**CITY OF MERCER ISLAND**

July 23, 2018

Re: Land Use Review Letter for a Reasonable Accommodation Request  
Regarding: Reasonable accommodation for an expanded driveway, walkways, and patio located at 6121 84<sup>th</sup> Ave SE Mercer Island, WA 98040; Parcel ID: 192280-0340

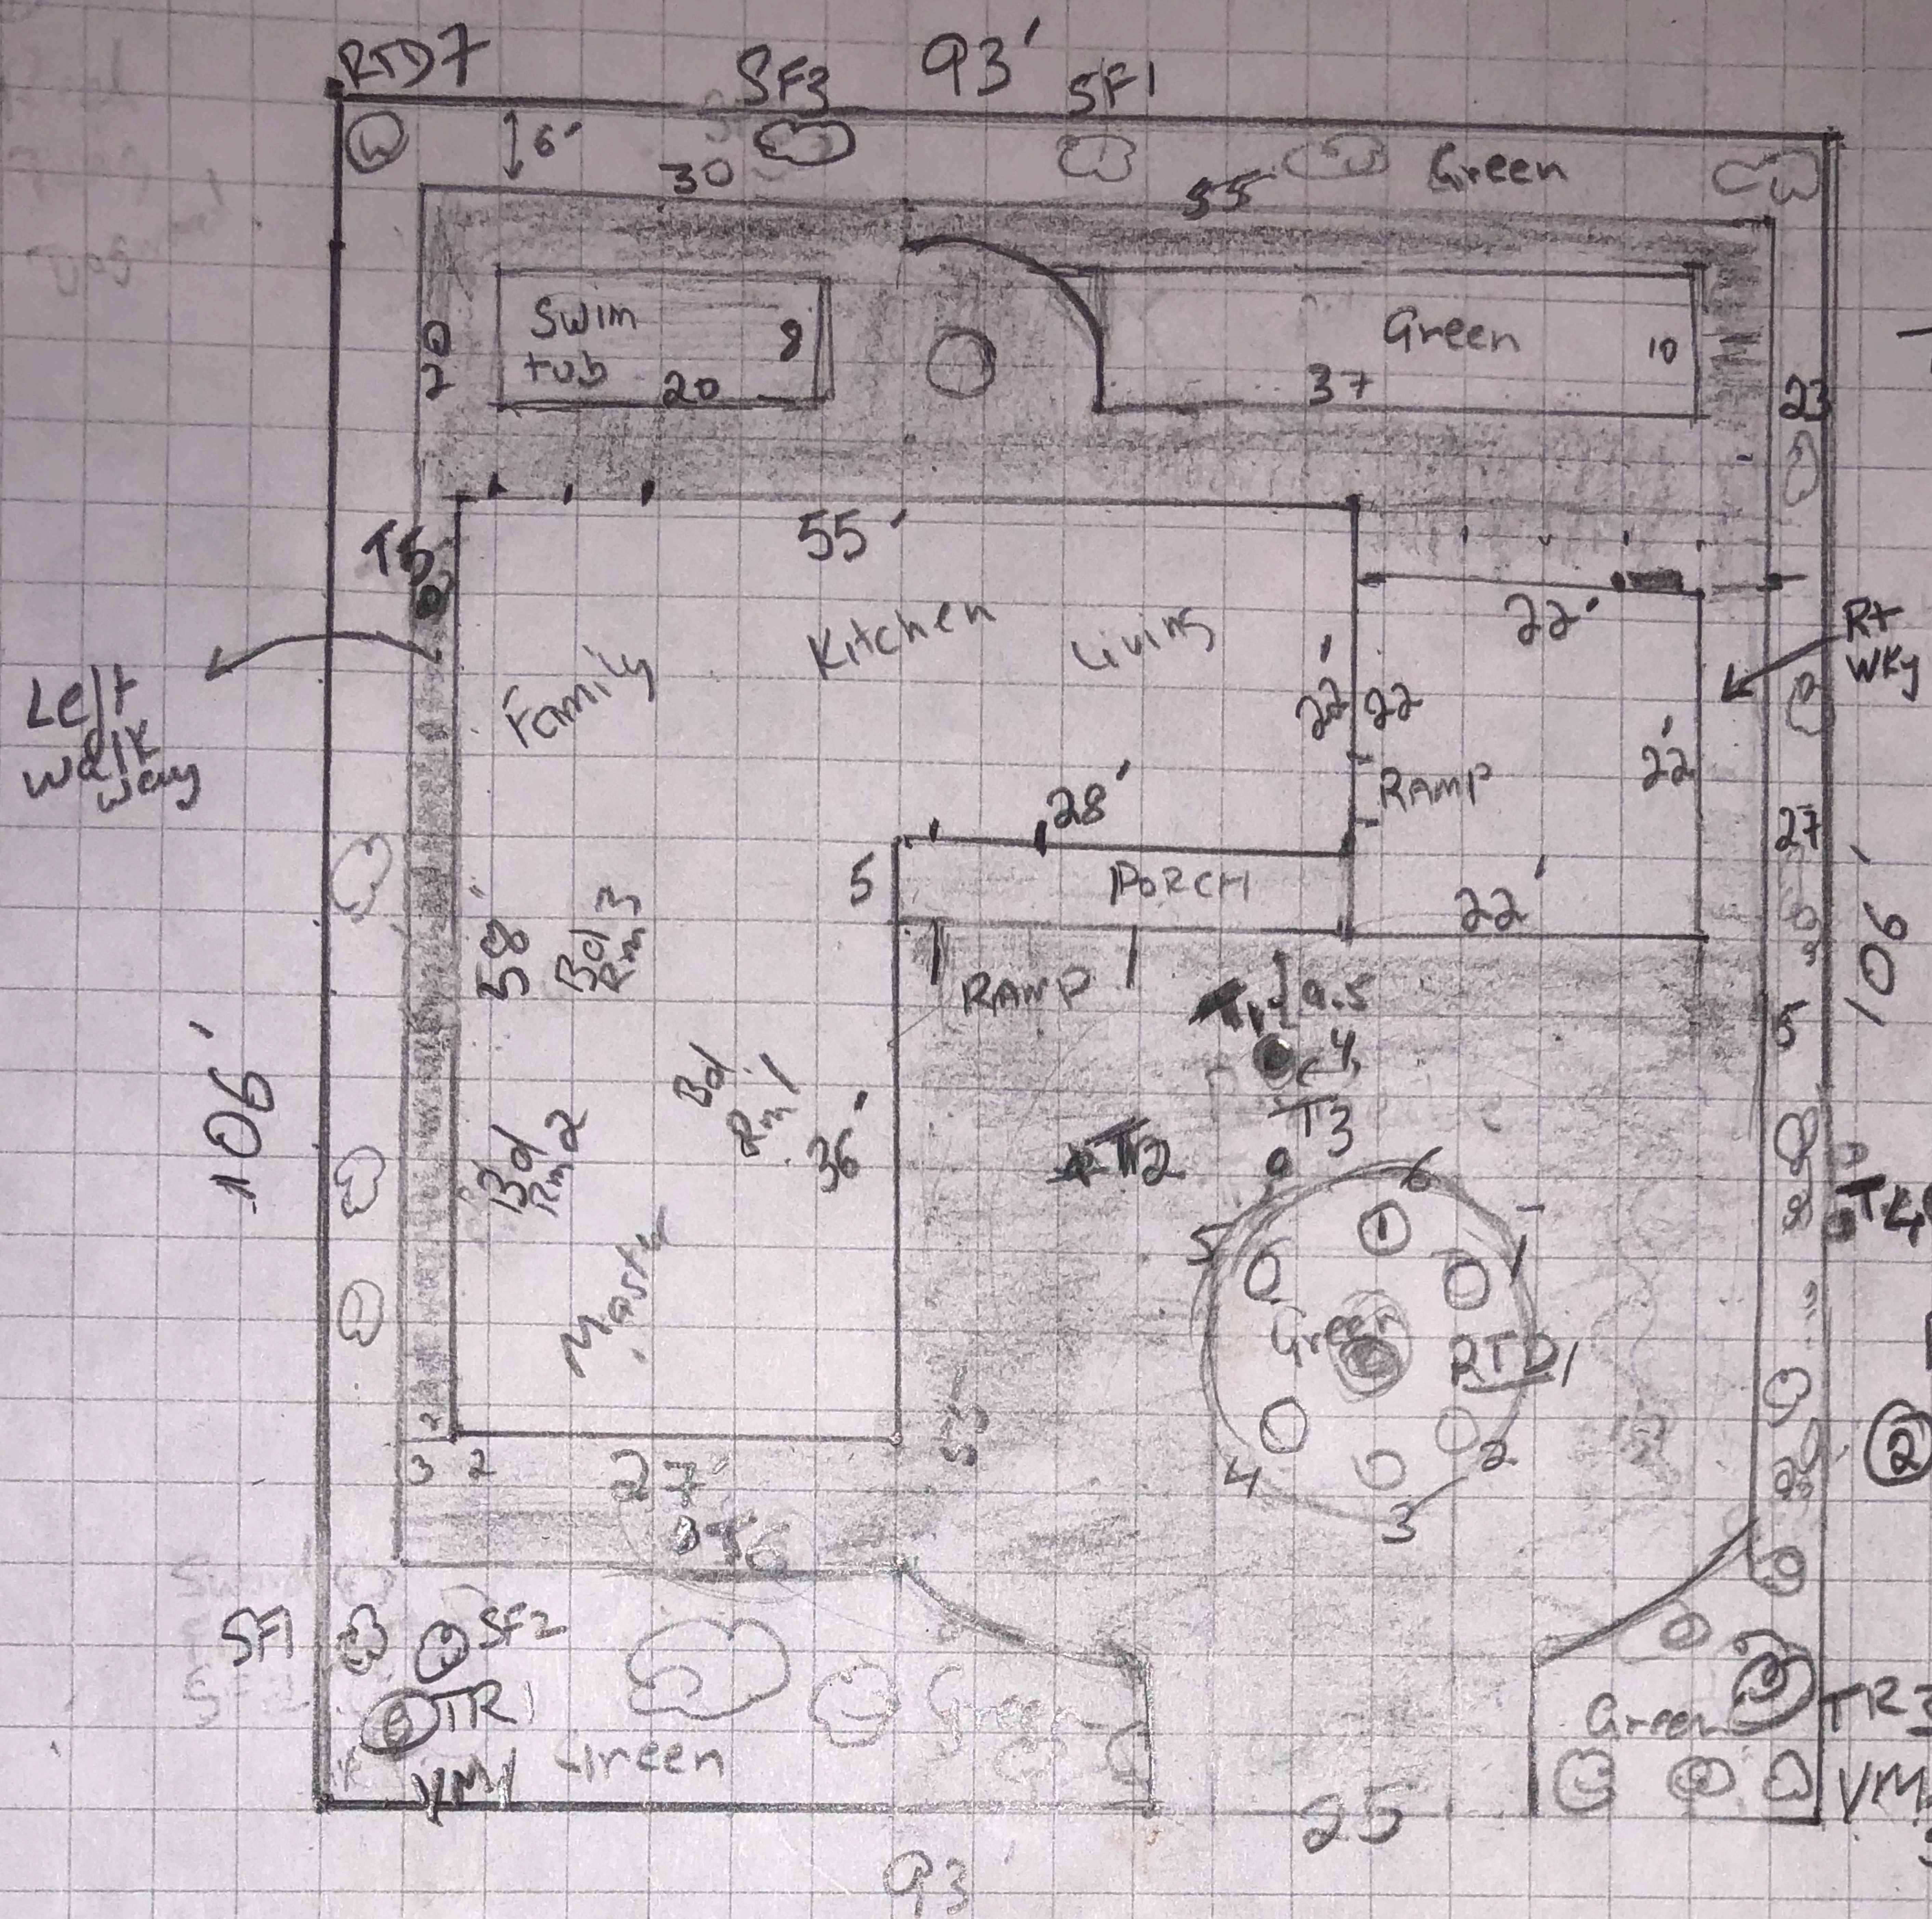
1. Please explore other options for the design of the driveway, as the City typically prohibits loop (double) driveways unless the property frontage along the street is 100 feet or more. Your property frontage is less than 100 feet. Some possible design options include but are not limited to the following:

- a) Hammer head driveway to accommodate vehicle turnaround on site;
  - b) Circular accommodation on-site using one driveway; or,
  - c) Retain the existing head-in/back-out configuration.

2. A landscaping plan is required, to mitigate for impacts resulting from the additional lot coverage and hardscape. Please provide additional landscaping information, that includes the following:

- a) A landscaping plan that specifies the proposed type of plants, species, location of plantings, and estimated quantity. Please note that native or adaptive species are preferred; and,

- b) A narrative how the plants provide a natural screening barrier.
